FALCON MEADOWS AT BENT GRASS FILING NO. 2

A REPLAT OF TRACT G, BENT GRASS RESIDENTIAL FILING NO. 2 AND
A PORTION OF THE WEST HALF OF SECTION 1,
TOWNSHIP 13 SOUTH, RANGE 65 WEST OF THE 6TH PRINCIPAL MERIDIAN,
COUNTY OF EL PASO, STATE OF COLORADO

### FALCON MEADOWS AT BENT GRASS FILING NO. 2

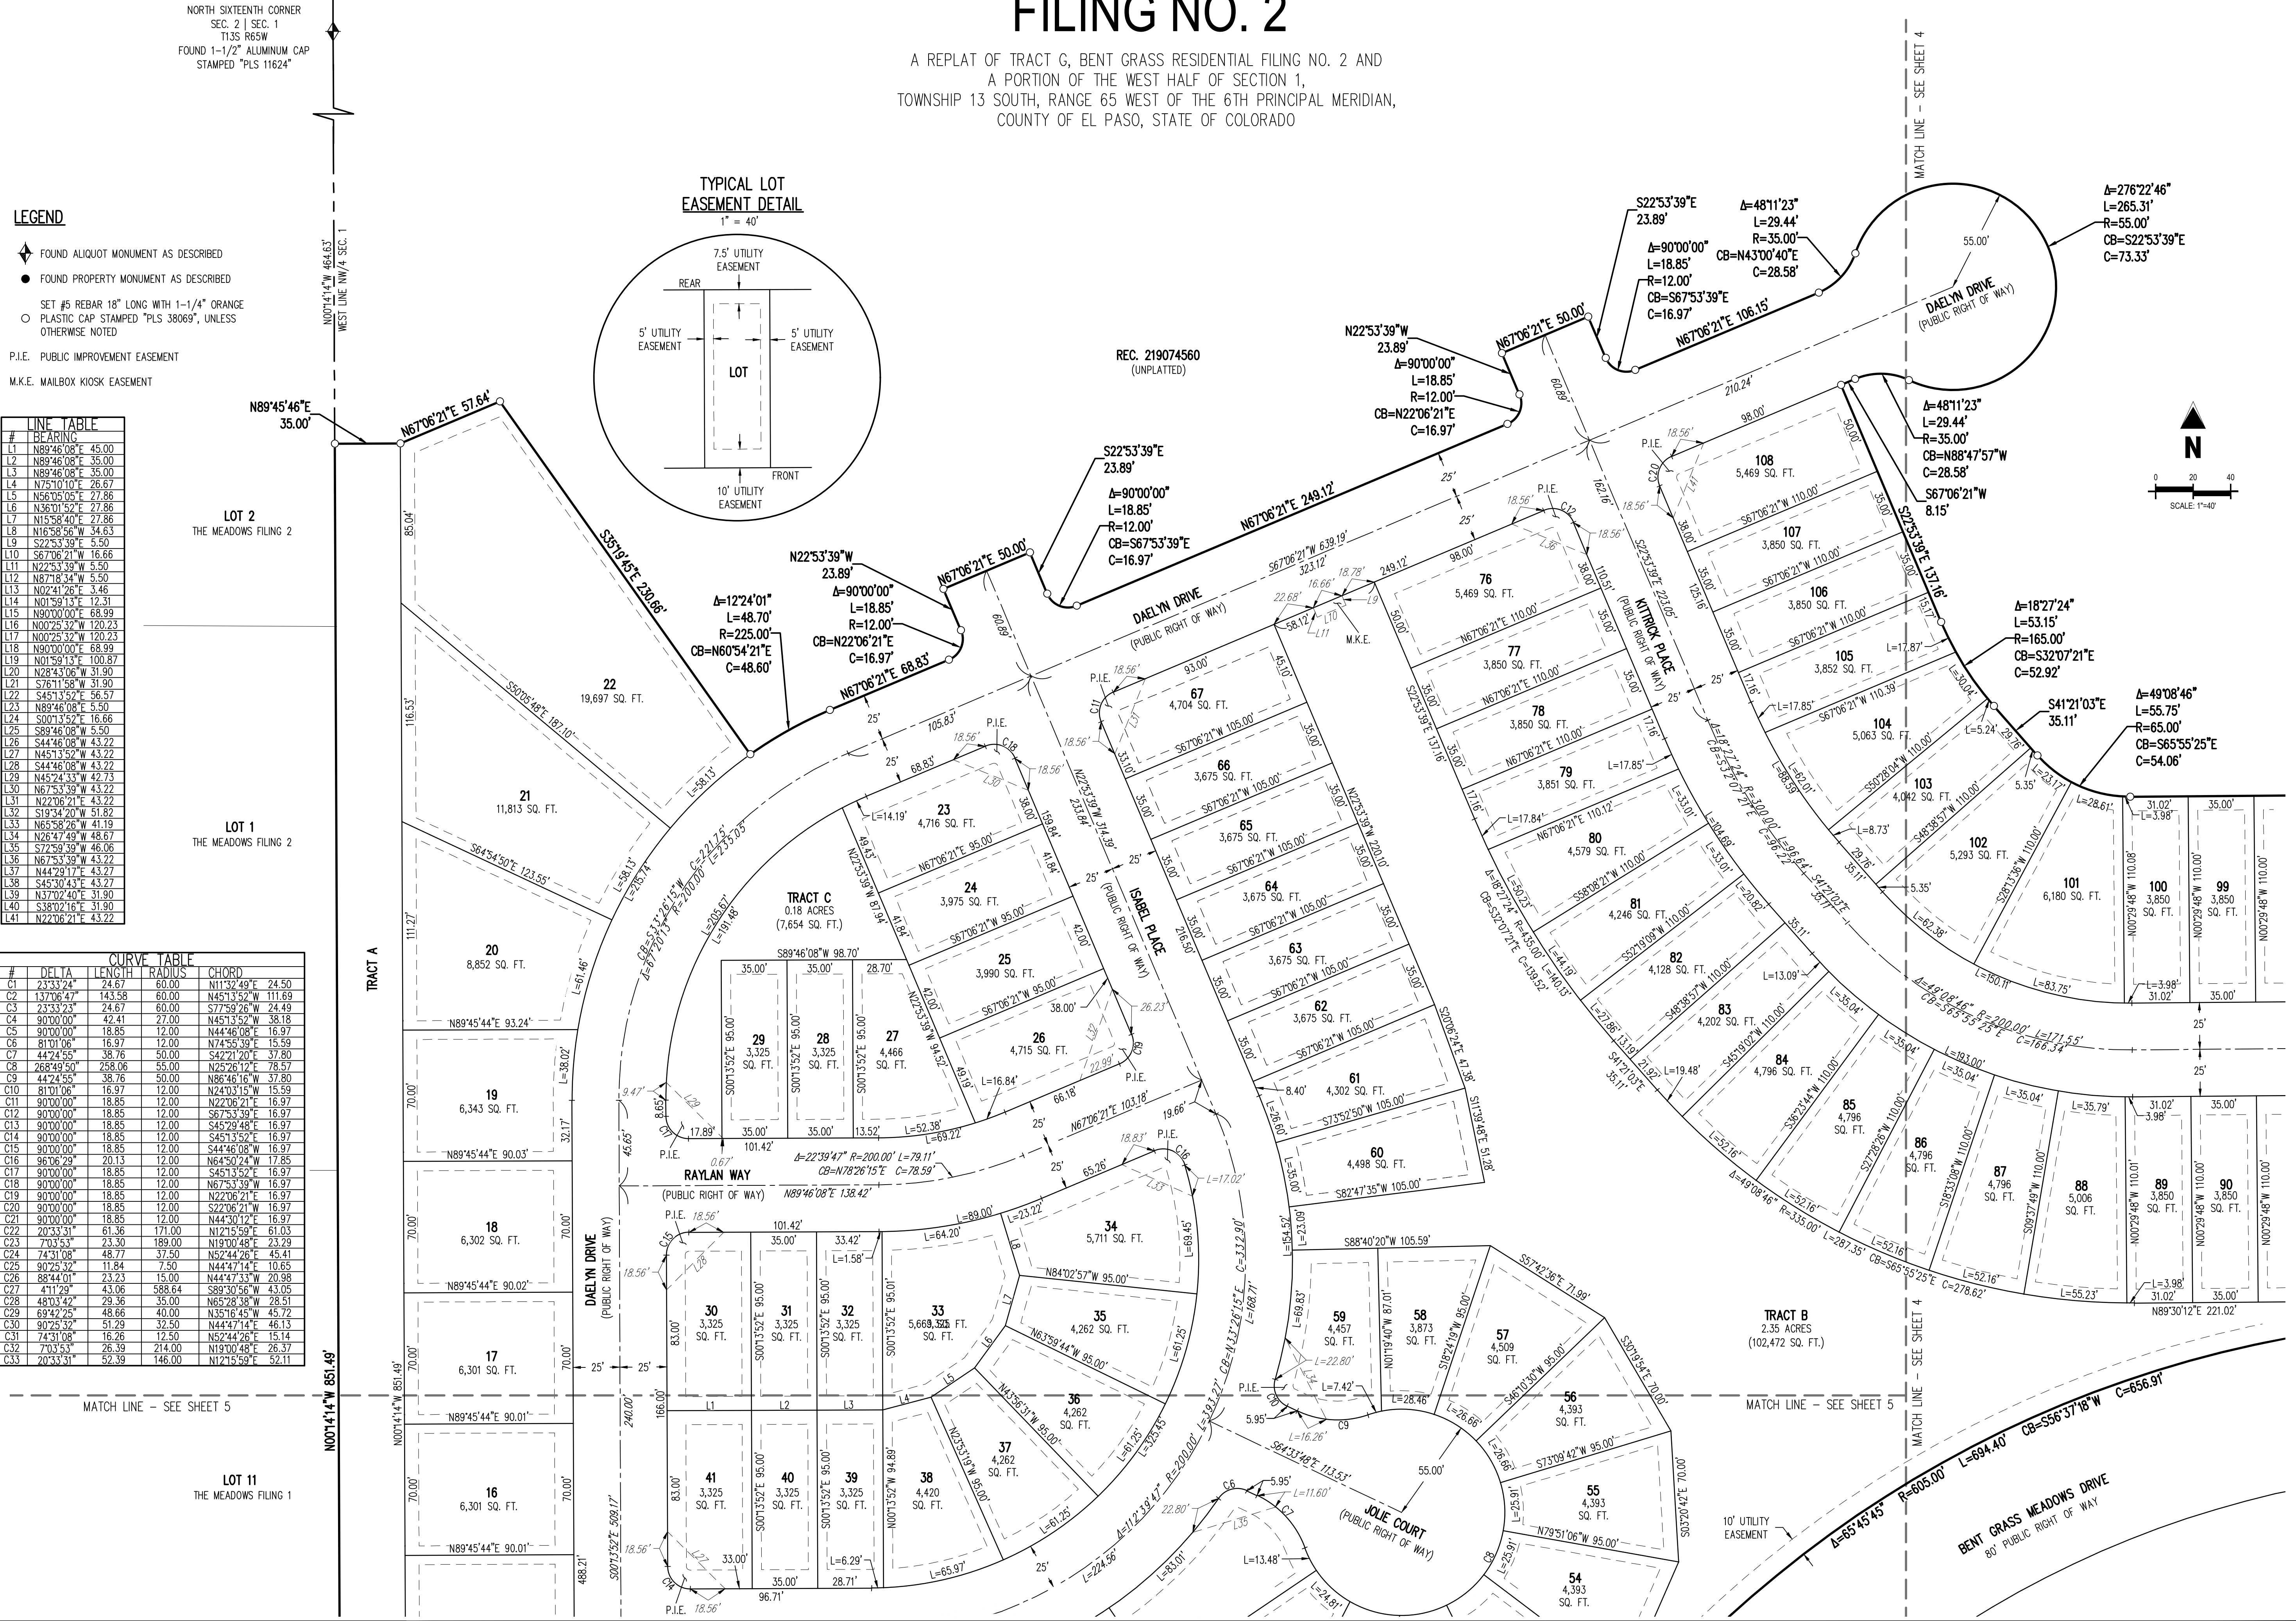
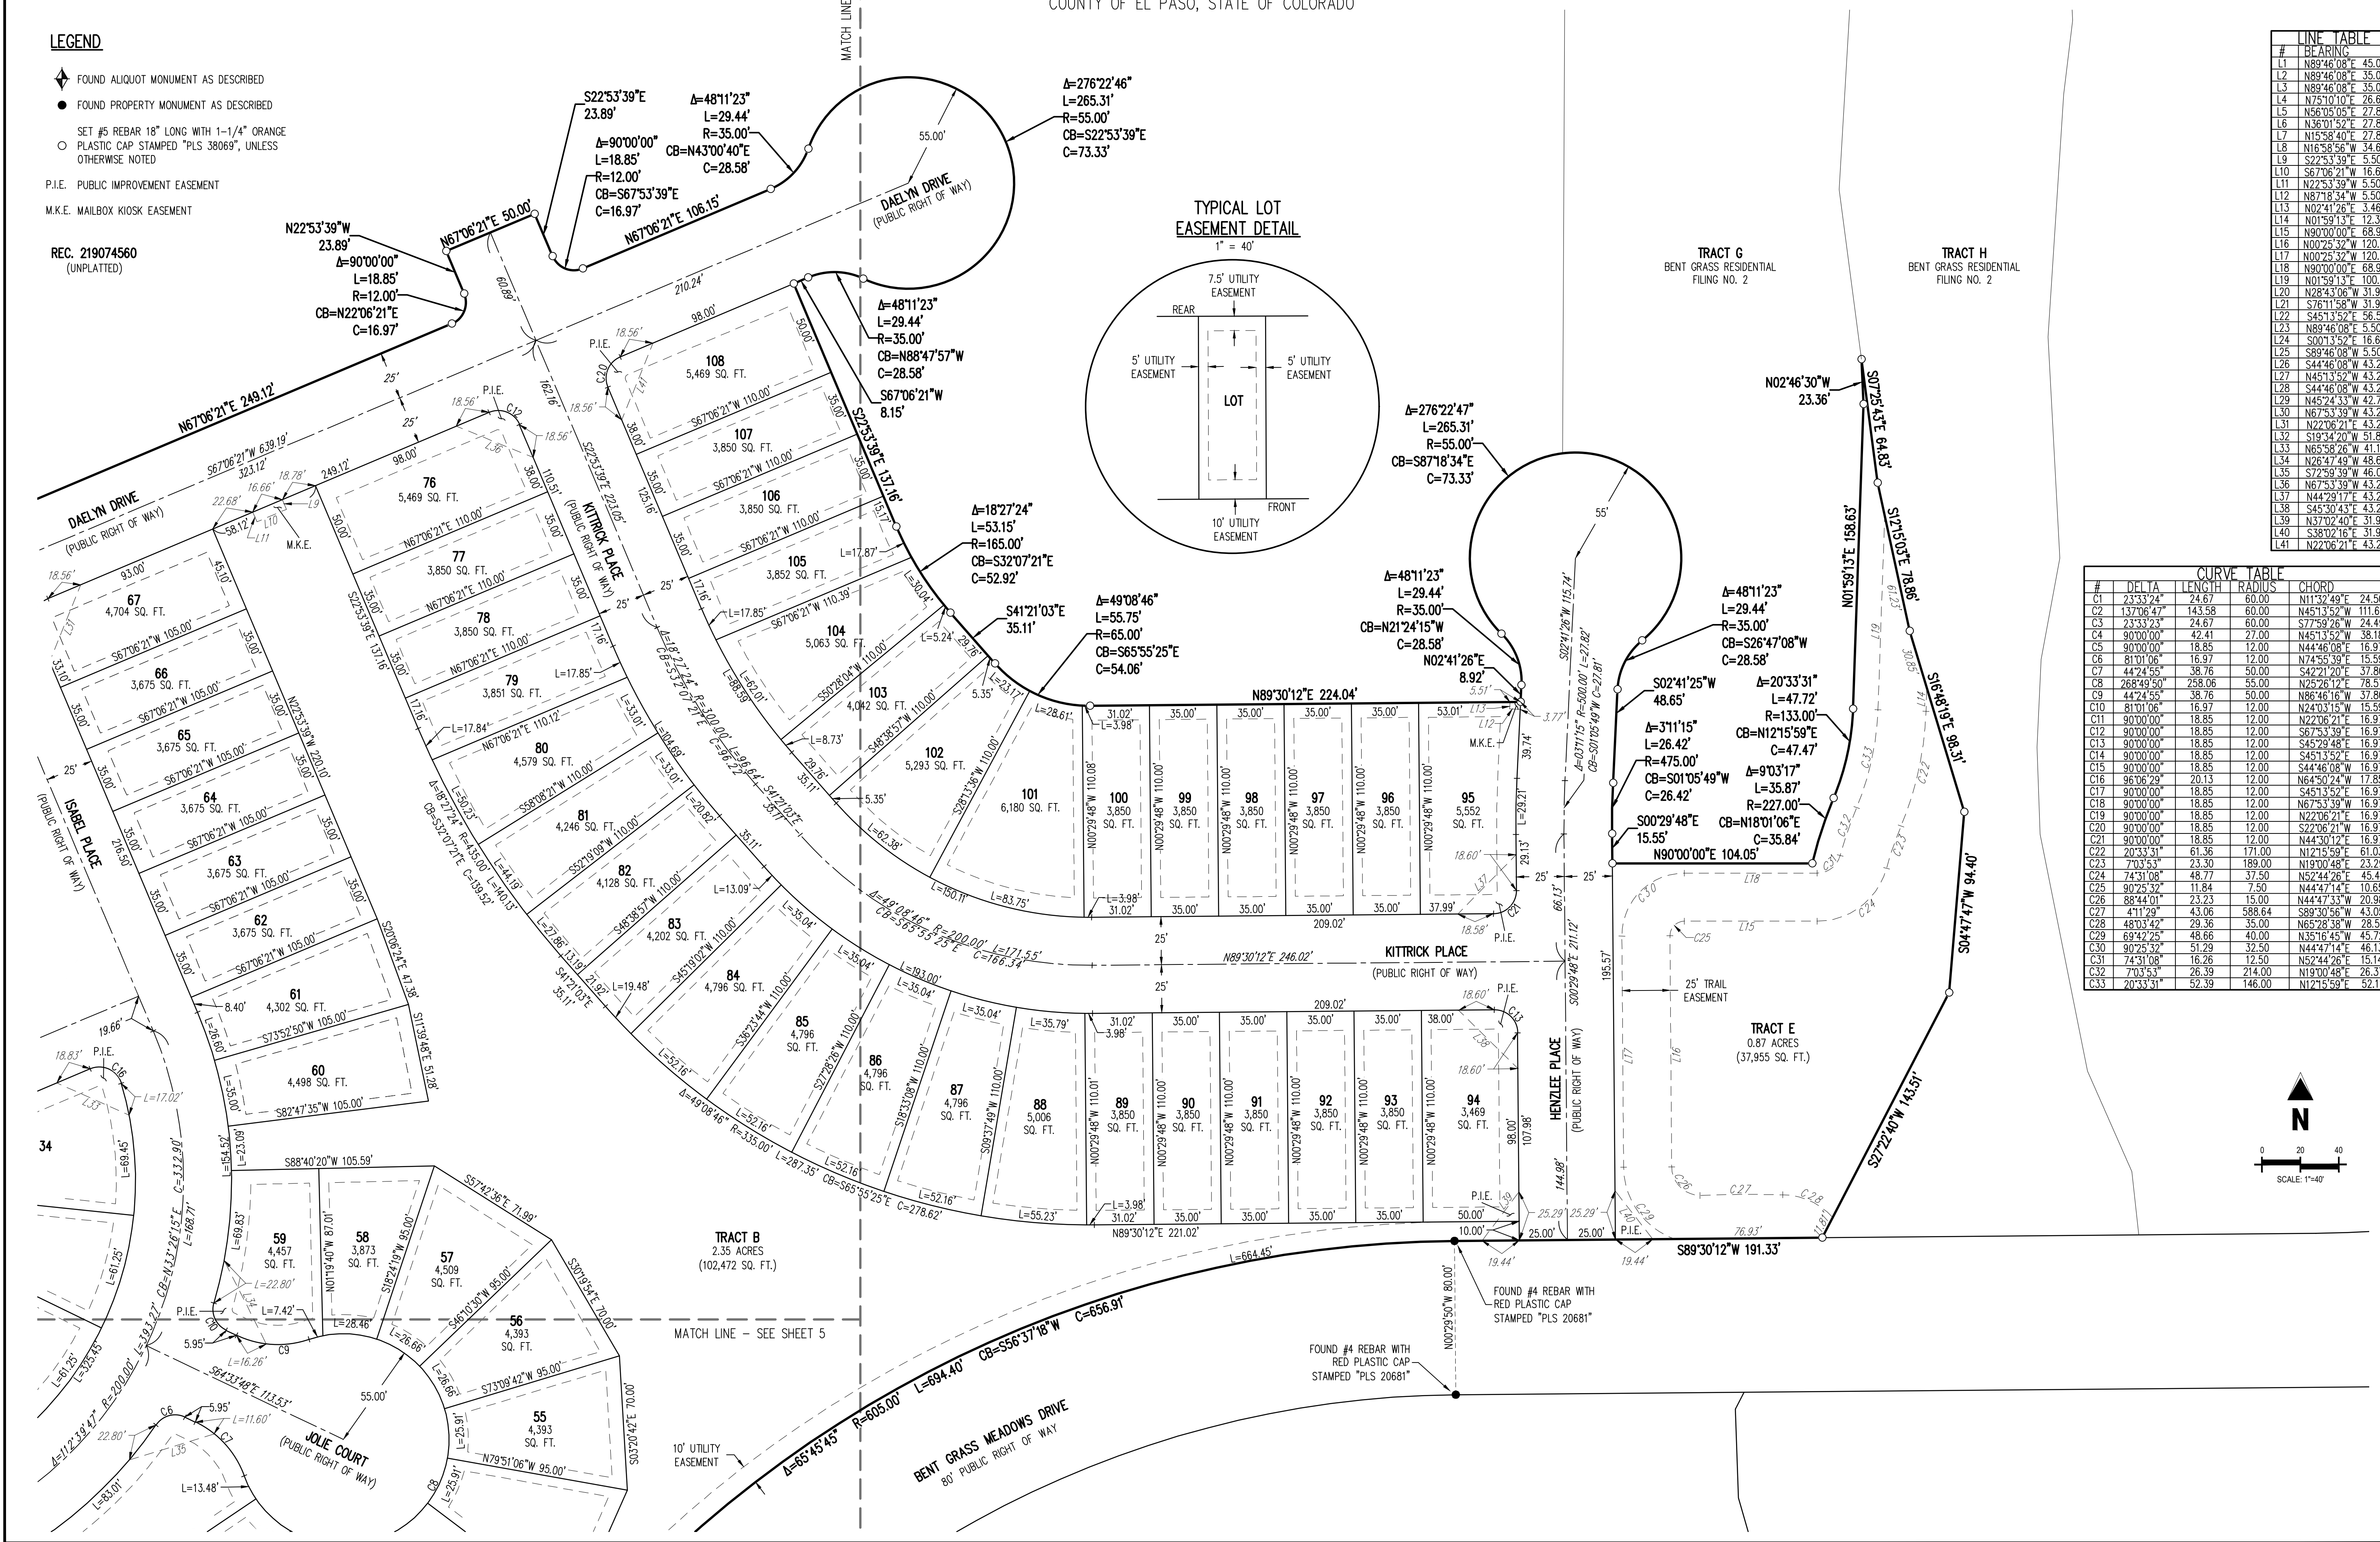
ALL ACCESS ROADS SHOULD BE NOTED ON PLAT

PROVIDE A NOTE FOR INSTALLATION AND MAINTENANCE RESPONSIBILITIES FOR TWO TYPES OF FENCES ON SHEET 1 OR 2; ADD EACH TO FAE

TRAIL NOTES SHOULD BE ADDED: WHO BUILDS AND MAINTAINS- COST SHOULD BE INCLUDED IN FAE

also show drainage easement
